**Subject: Maverik Gas and Convenience Store Traffic Impact Study  
Southwest quadrant of I-25 and Jefferson Street  
Albuquerque, Bernalillo County, New Mexico**

This letter is to inform you that the **FINAL** Traffic Impact Study (TIS) for the proposed Maverik Store on the southwest quadrant of I-25 northbound off-ramp and Jefferson Street Interchange dated March 18, 2019 has been reviewed.

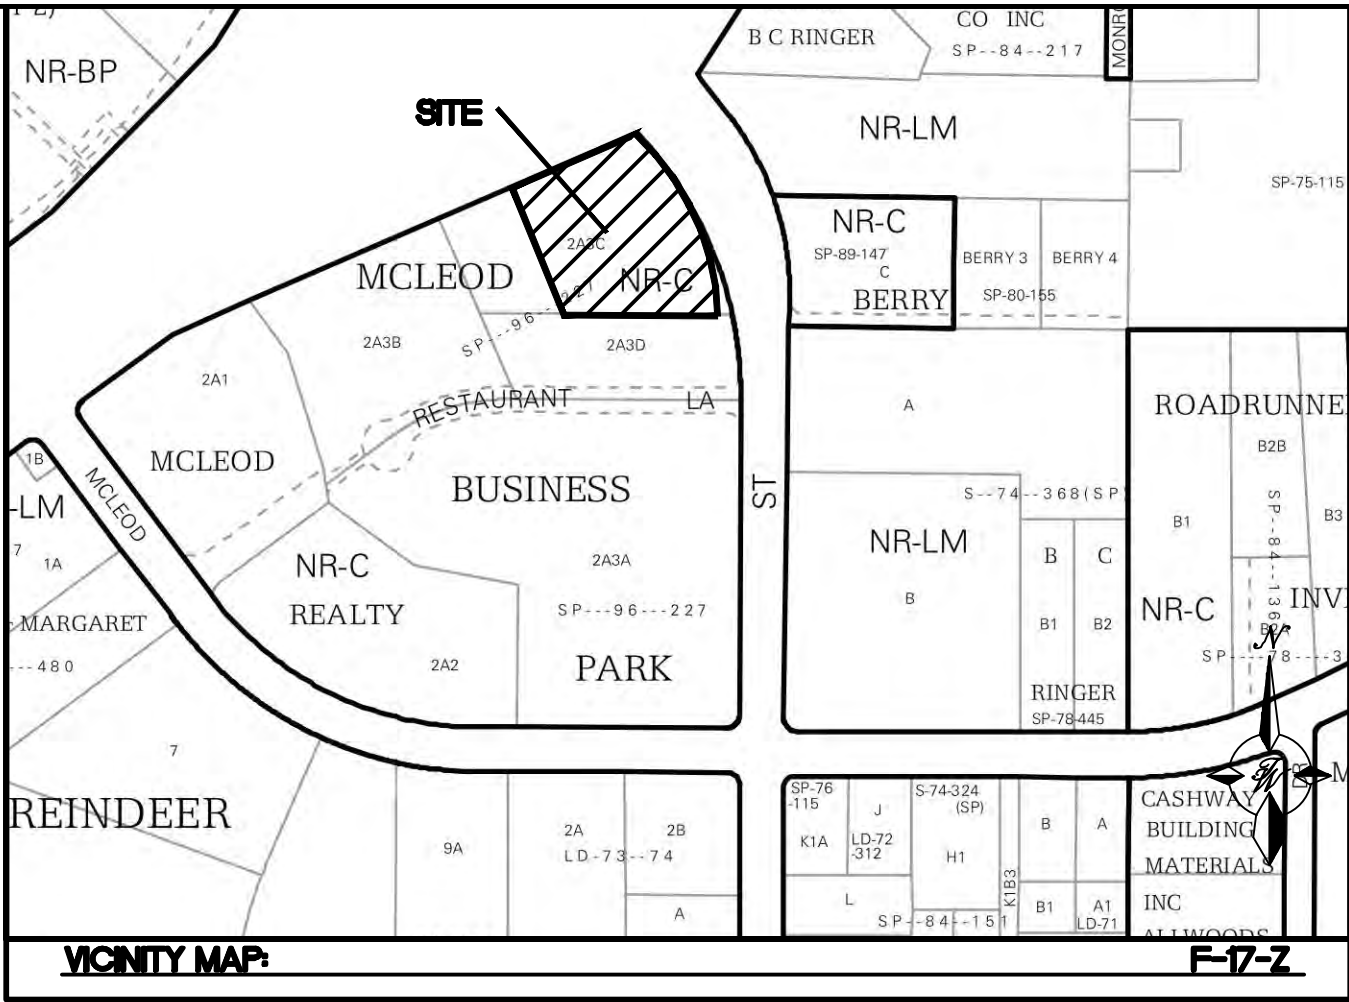
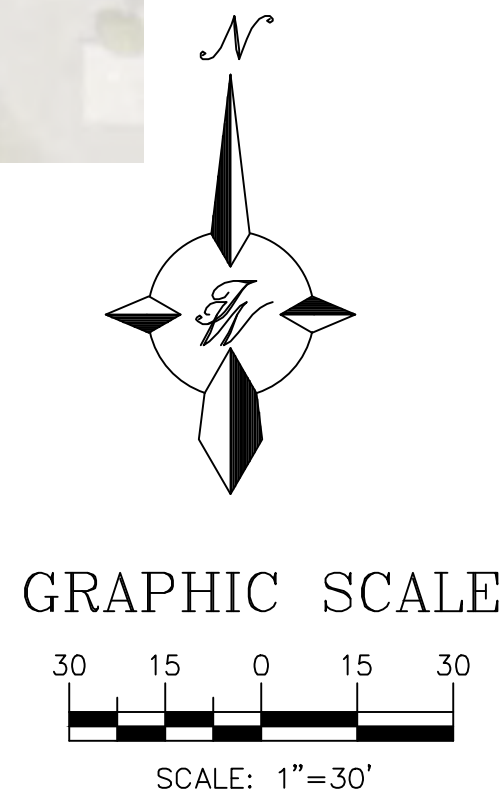
1. The property owner shall submit a Commercial Driveway Application for the entire property (including both driveways).
2. The development shall construct ADA facilities along its frontage on Jefferson Street.

3. Driveway "A" shall be built as a RIGHT-IN ONLY driveway with enhanced median islands to prevent a potential left/right-out from occurring.
4. The development shall construct a deceleration lane at Driveway "A" that is 200 feet in total length (including taper).

5. Driveway "B" does not meet the State Access Management Manual's corner clearance spacing for a full access.
6. The development shall provide a platted access easement to the property to the south to prevent an additional access request along Jefferson Street.
